**SUBJECT: Administrative Approval for Petition 2008-073 (Charlotte Mecklenburg Housing Partnership)**

**Double Oaks Phase II**

**DOUBLE OAKS PHASE II RE-ZONING PLAN SUBMITTAL FOR ADMINISTRATIVE AMENDMENT 5**

SP102

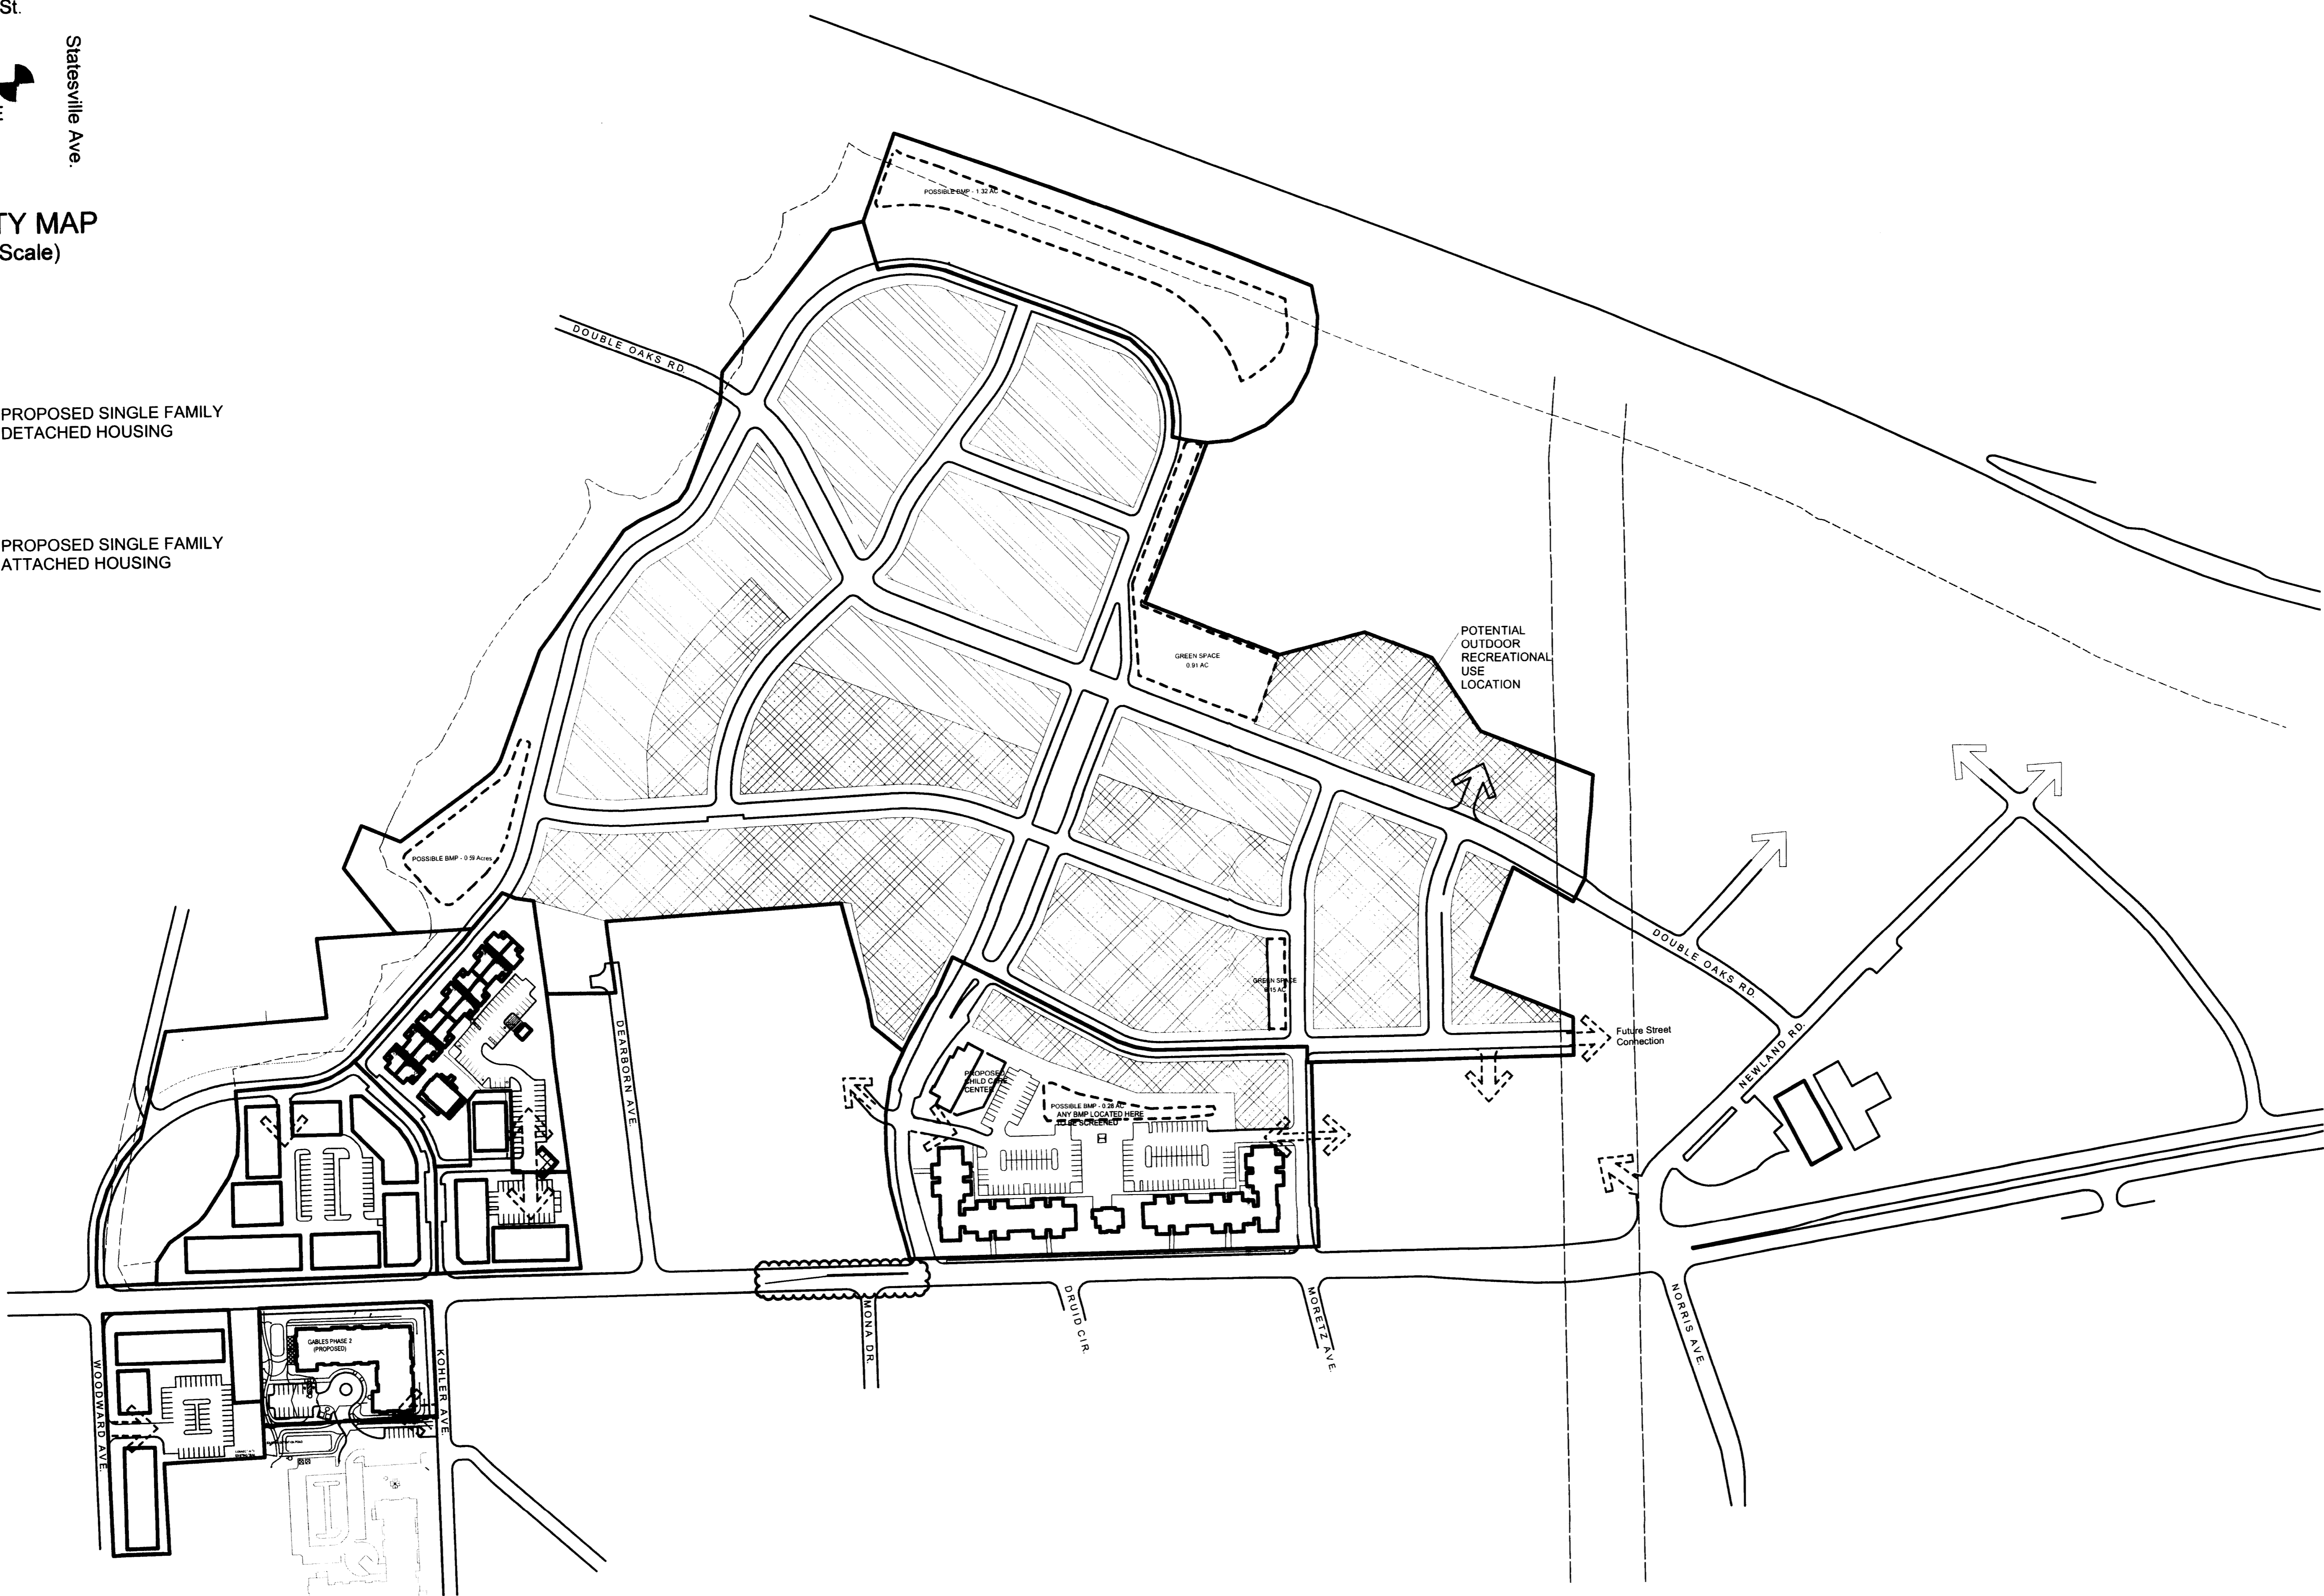
- Remove all notes on Sheet SP104 related to “Minimum Building Heights”.
- Re-allocate a portion of the site identified as single family attached to single family detached indicated on Sheet SP102.
- Modification of the phasing of the transportation commitments identified within Section 11.2(iii) on Sheet T101.
